April 13, 2015

**Subject: Century Tire Plaza – 195 Kennebec Street
Project ID# 2015-027
Review Comments Received April 8, 2015**

Prepared For:	Address City, State
Consultant:	Architect:
Project:	Century Tire
Revisions:	Scale: As indicated
Date: 05-01-2015	<b>BUILDING A ELEVATIONS</b>
<b>A2.01</b>

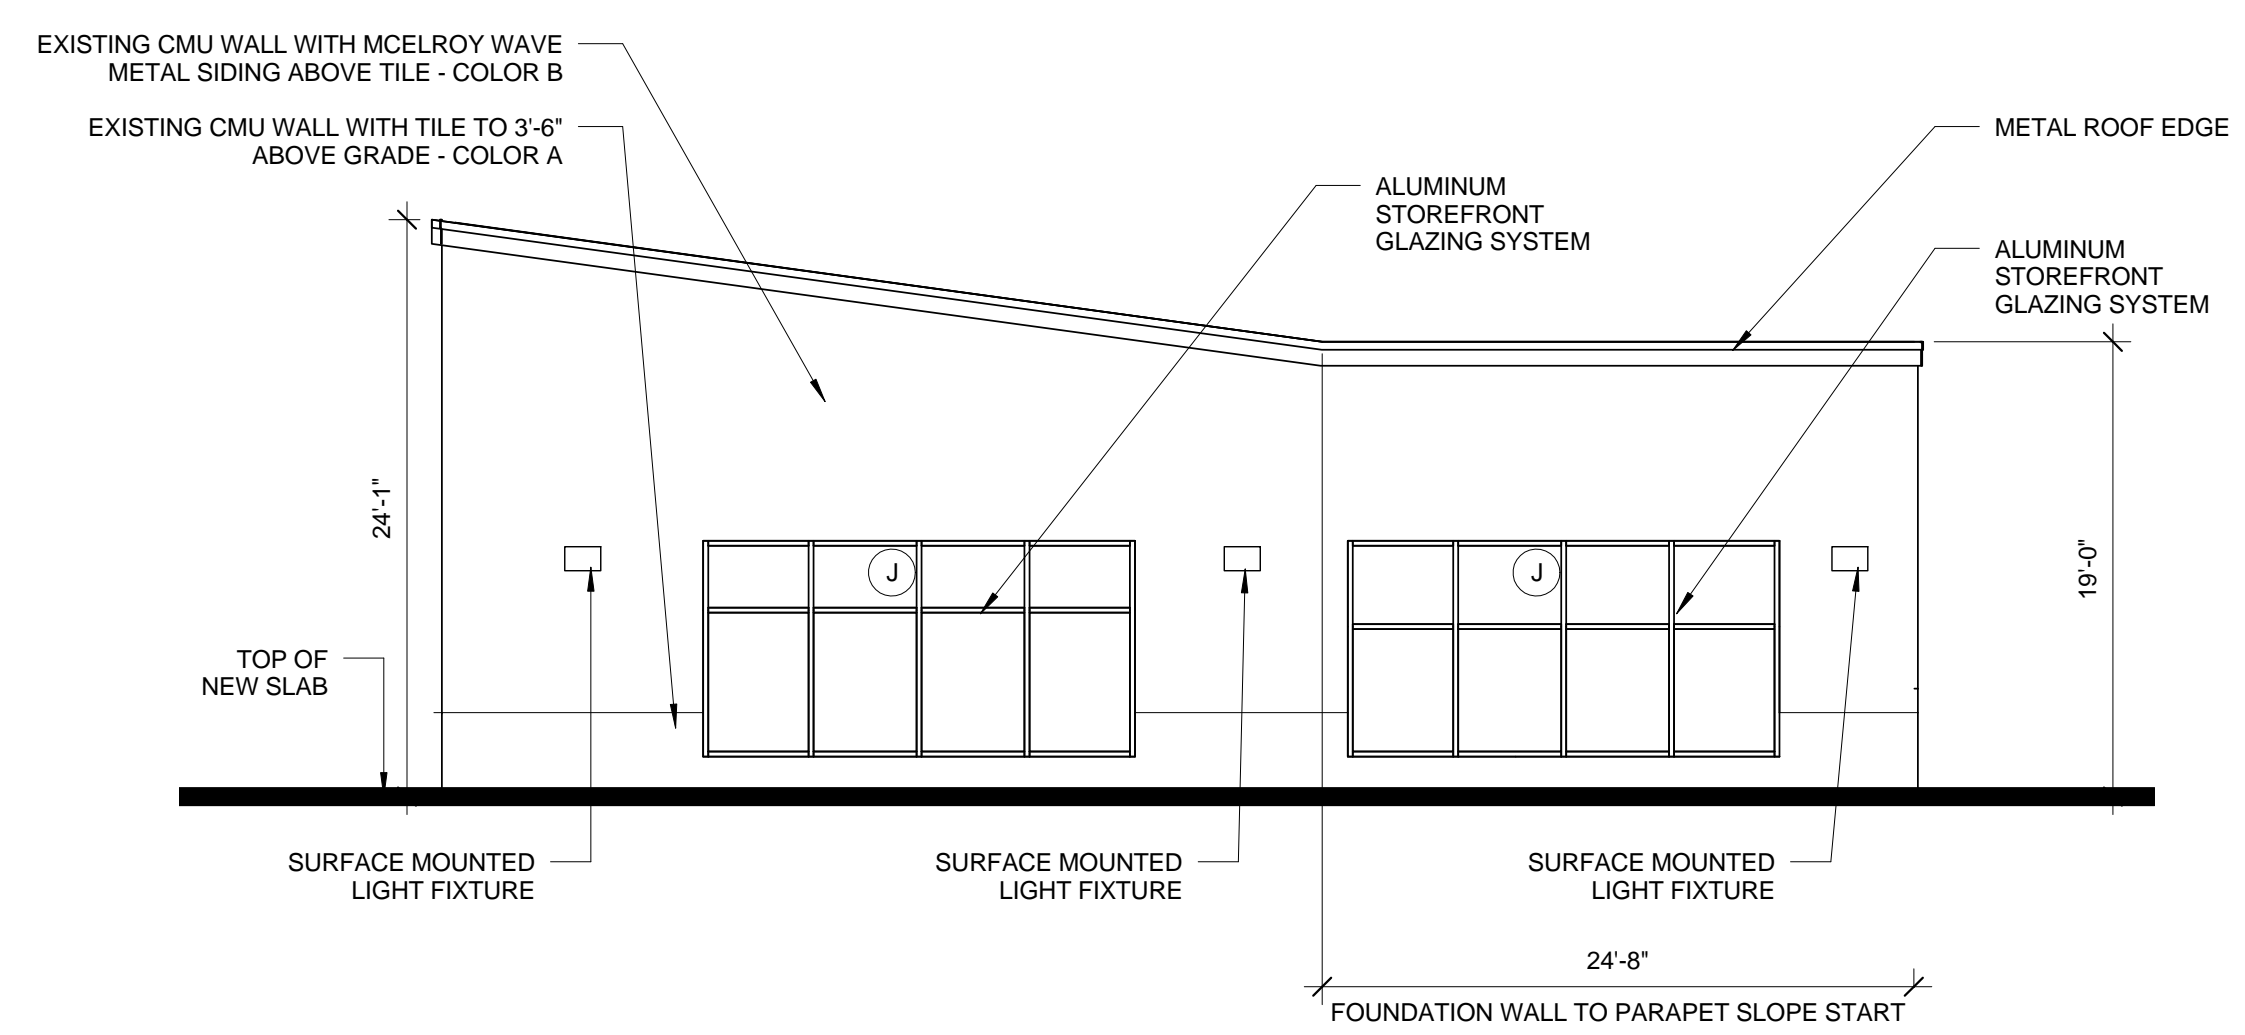
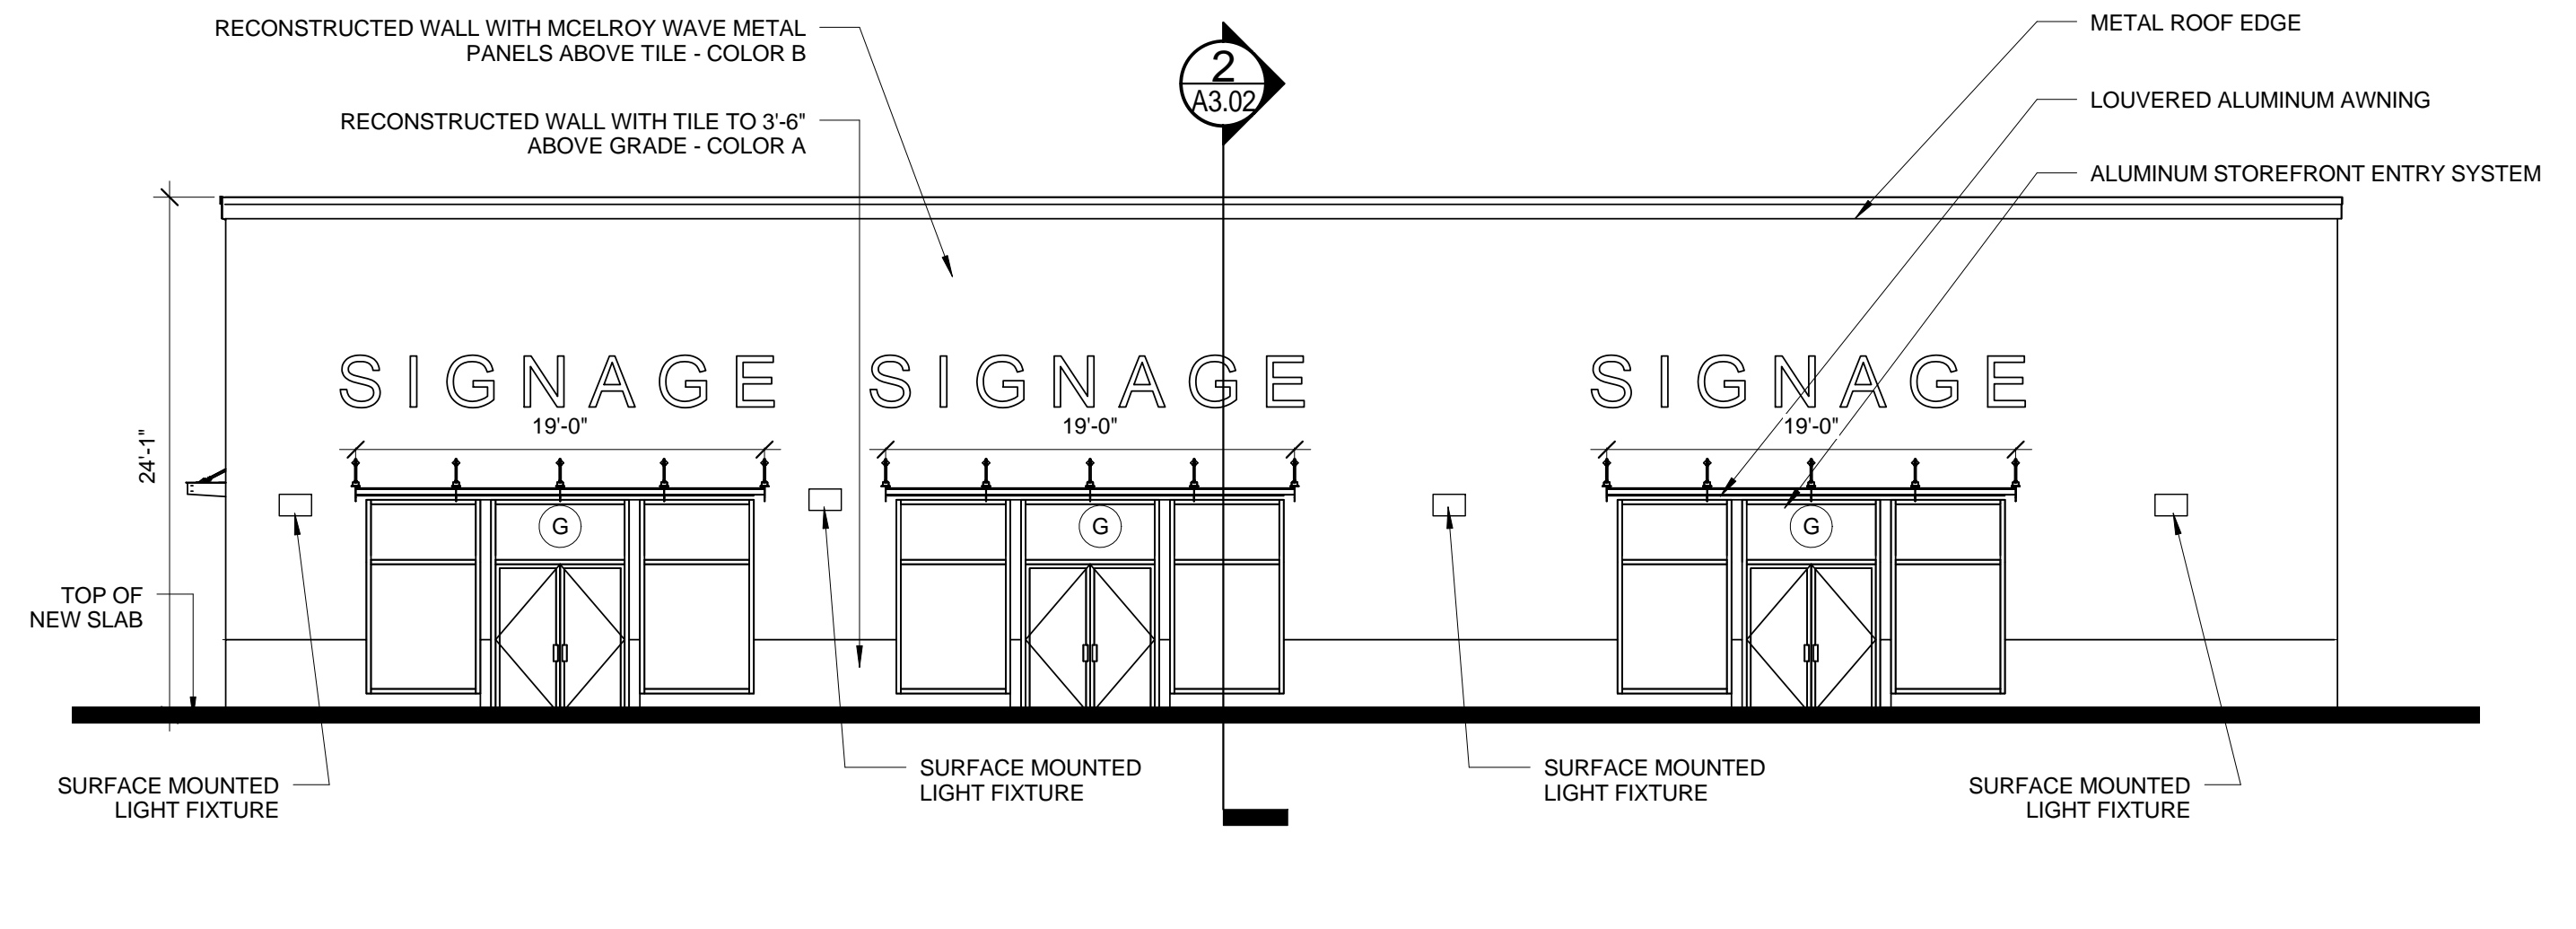
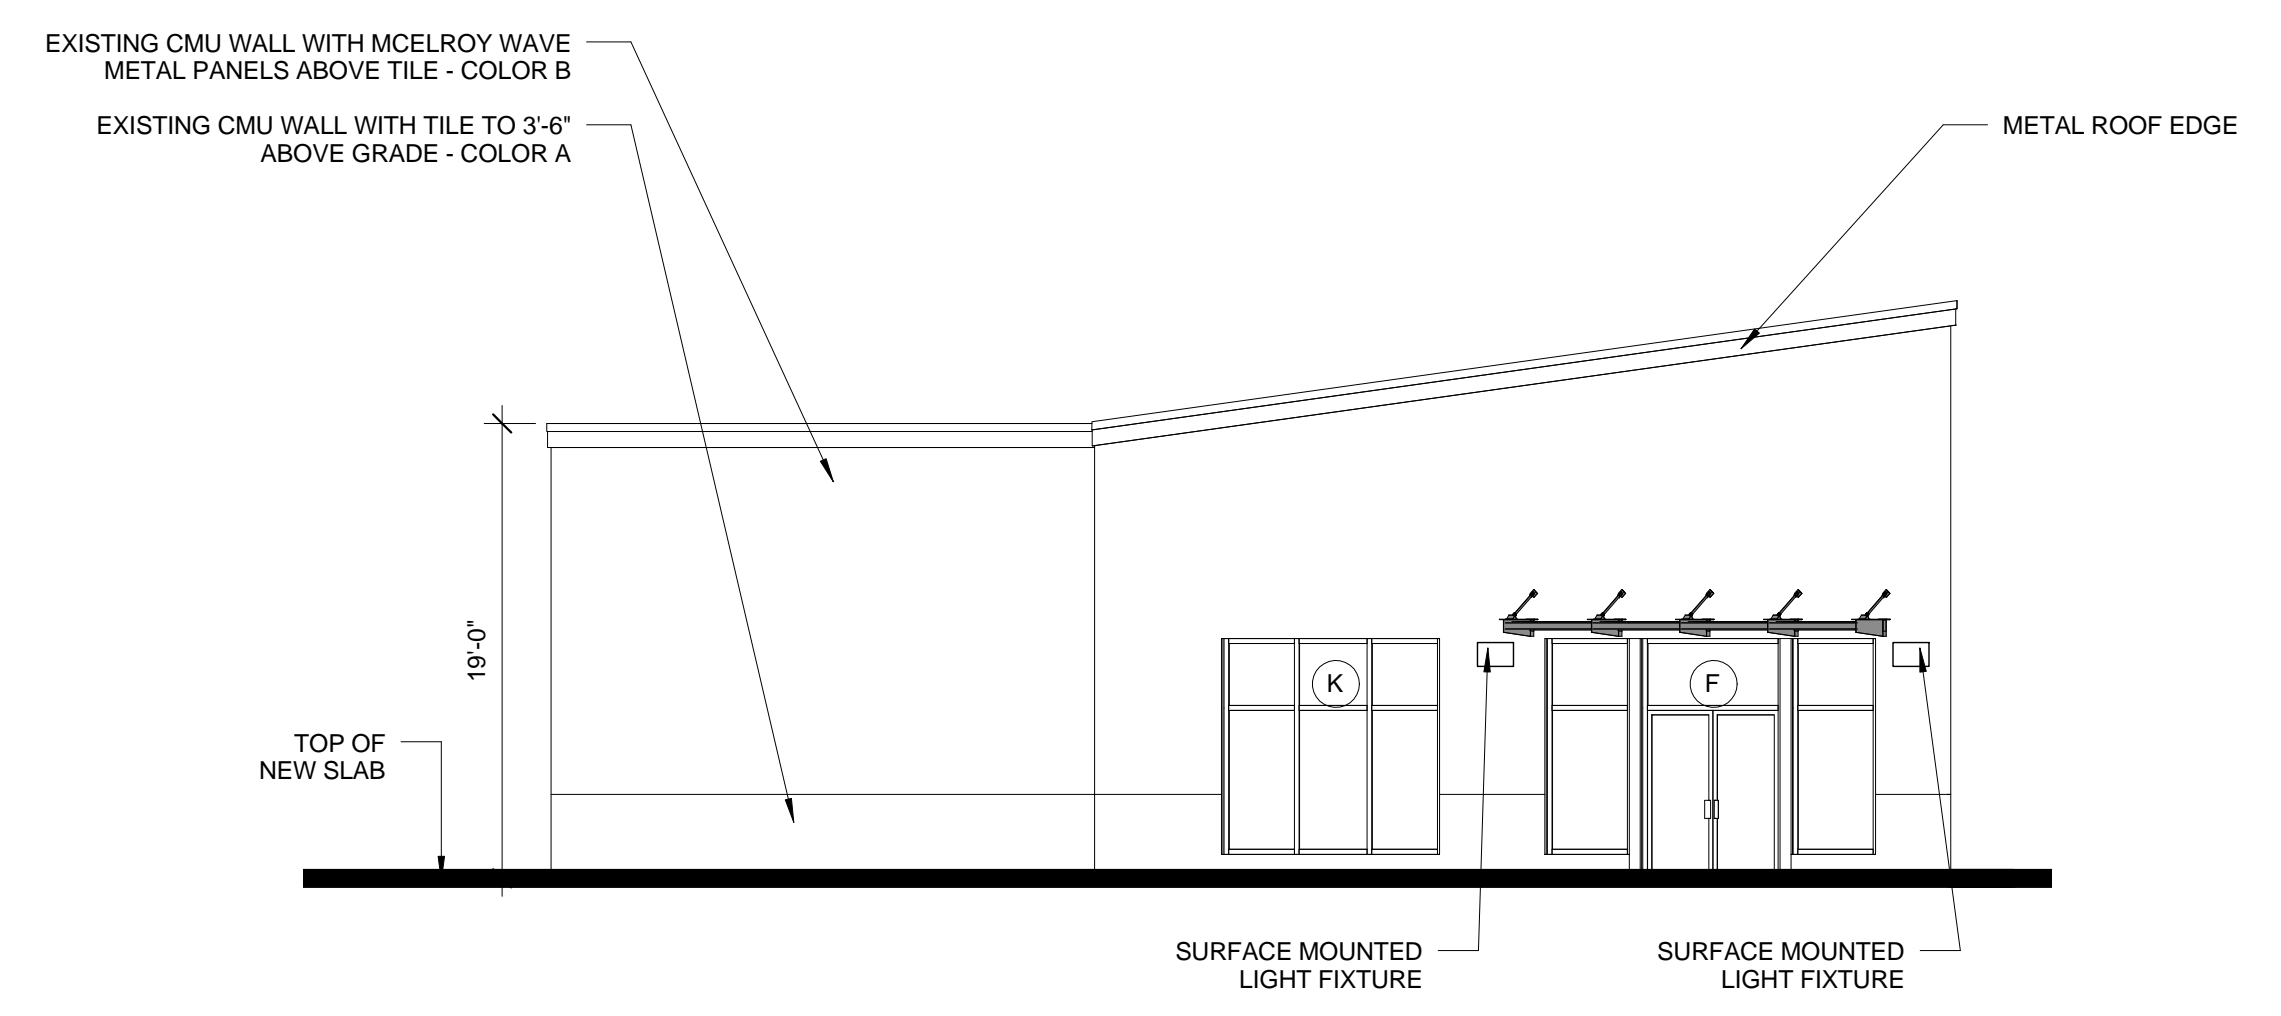
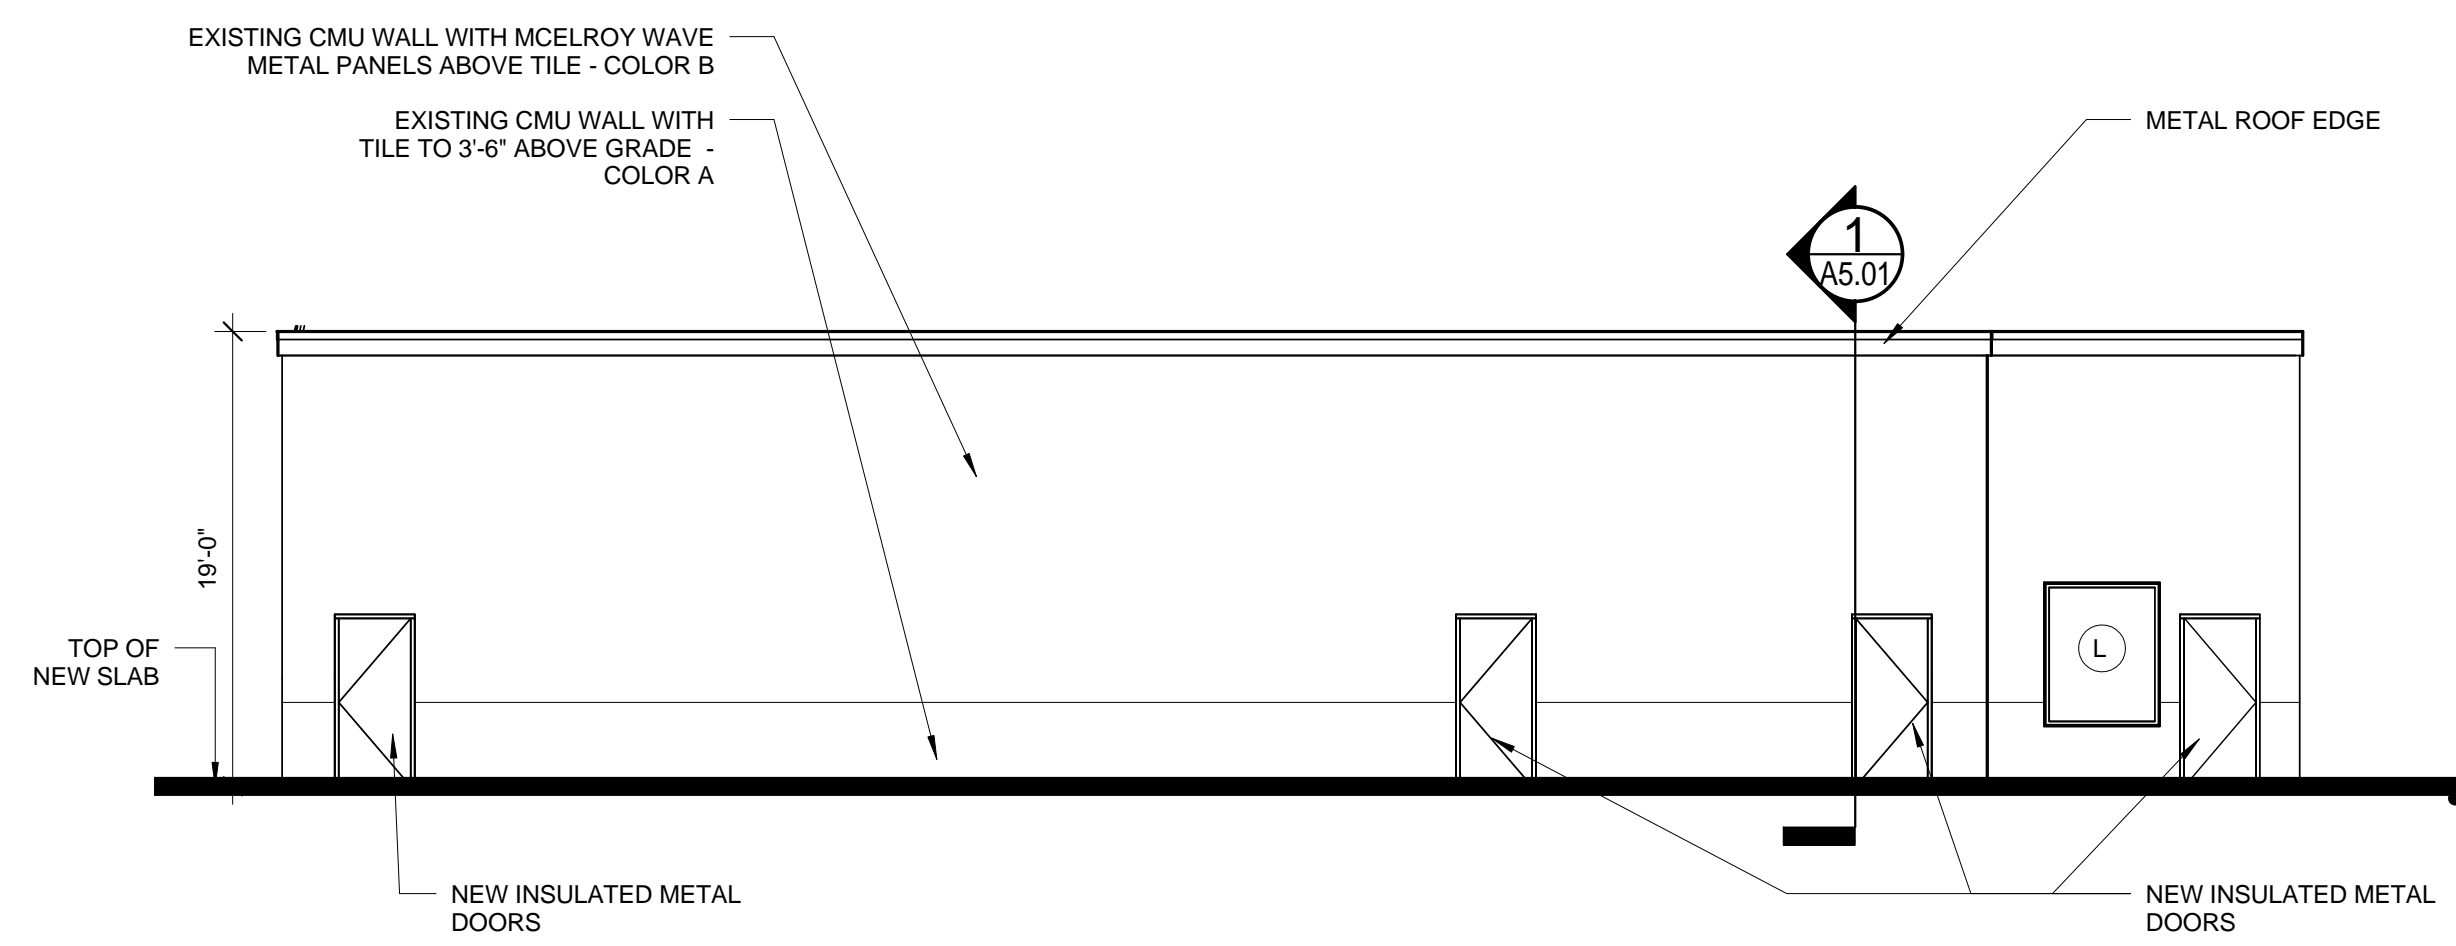
- *Building A – The street-facing façade and entry should be given equal treatment to the other building entrances. In this case, that includes a sign, light, and canopy.*

- *Building A – The street-facing façade and entry should be given equal treatment to the other building entrances. In this case, that includes a sign, light, and canopy.*

Revised architectural plans will be provided under separate cover.

Revised architectural plans will be provided under separate cover.
